REVISION/DEFERRED SUBMITTAL FORM

Site Address 7450 N Mercer Way

Permit Number 1904-048

Eliminate pool fence. Install ASTM F1346 compliant safety covers at swimming pool & spa.

Drawing file: REV3 / kell a-1.1 site plan-210520.pdf

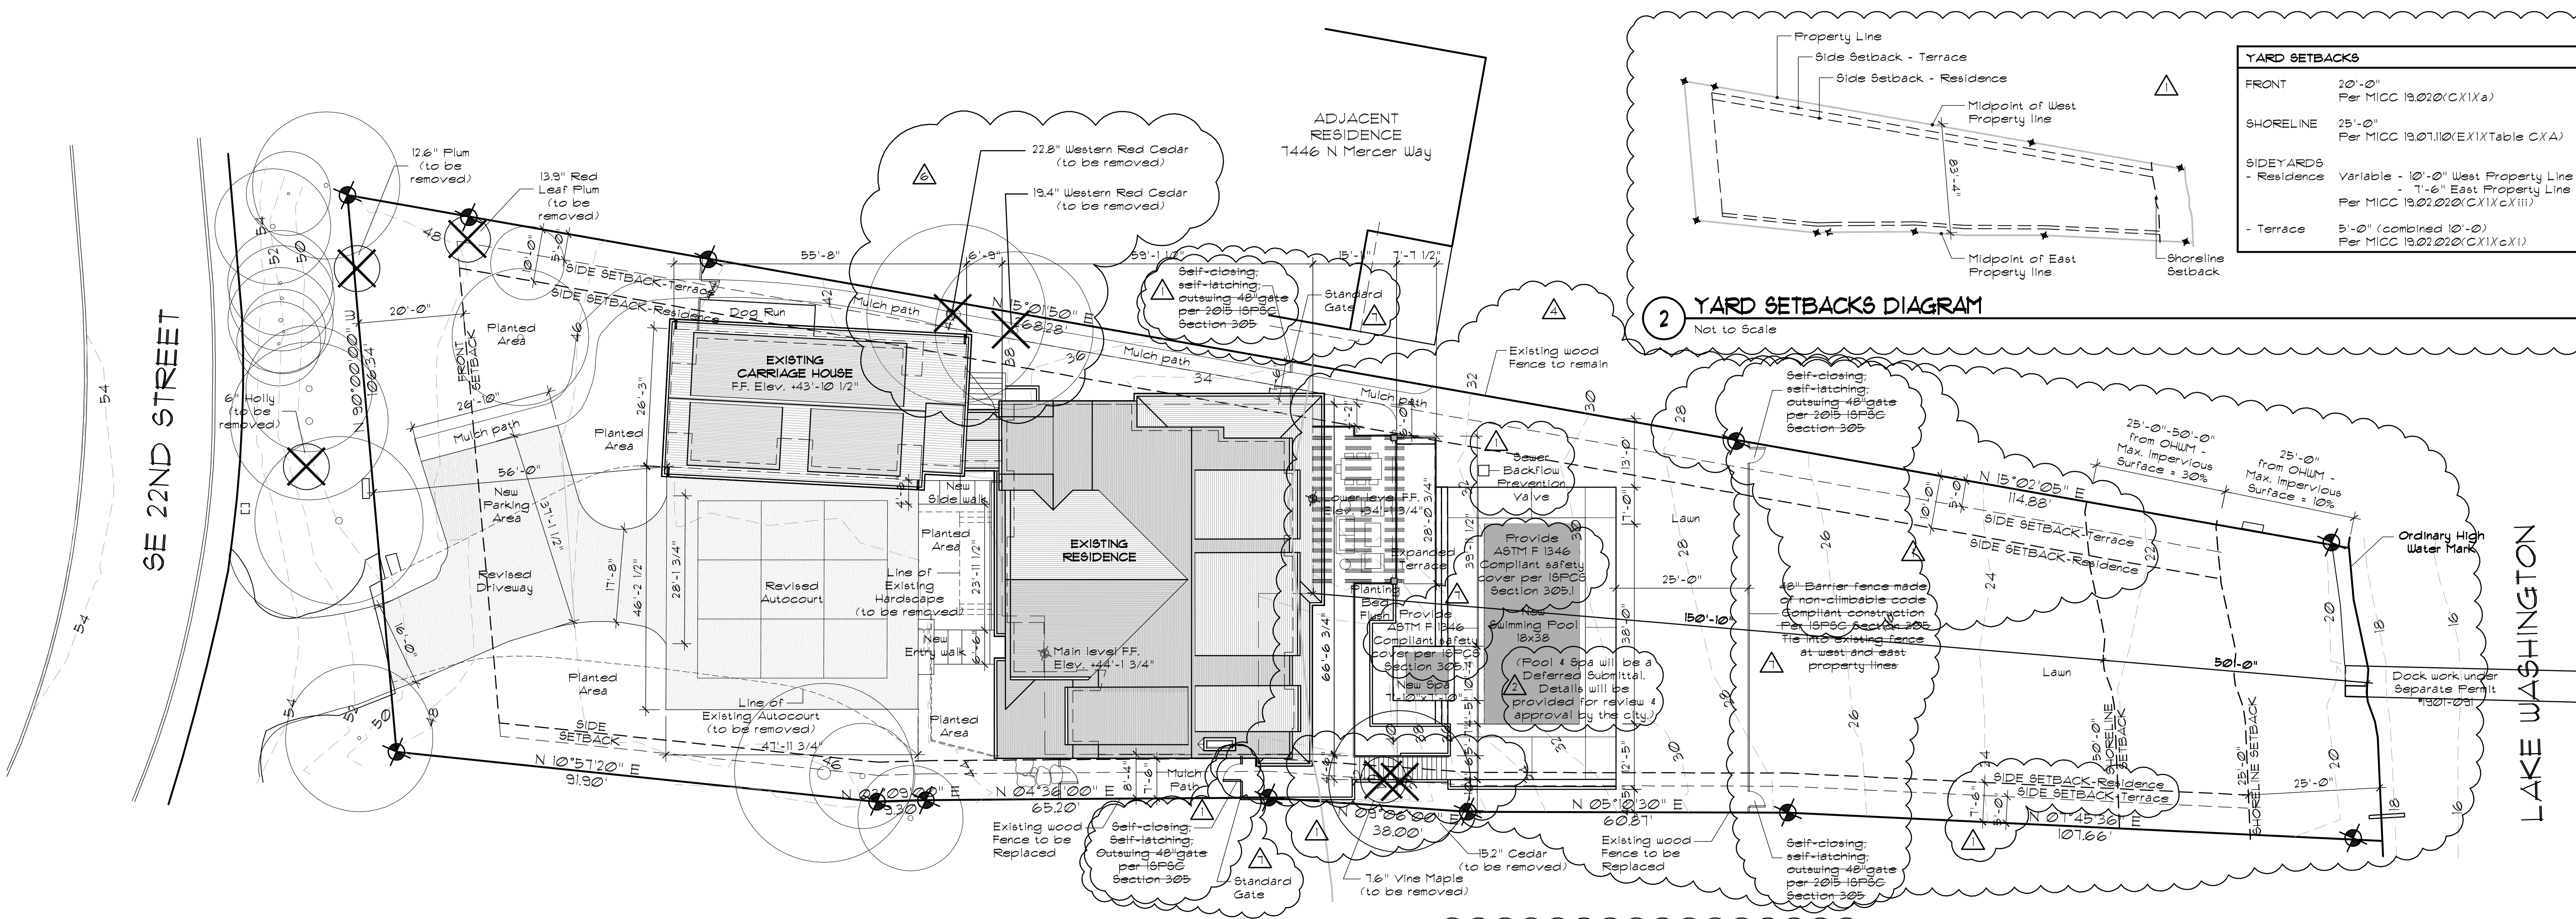
Sheet #	A-1.1	Site Plan (pool & spa safety barrier eliminated; ASTM F1936 covers added)
Sheet #		
Sheet #		
Sheet #		
Sheet #		
Sheet #		
Sheet #		
Sheet #		
Sheet #		
Sheet #		
Sheet #		
Sheet #		
Sheet #		
Sheet #
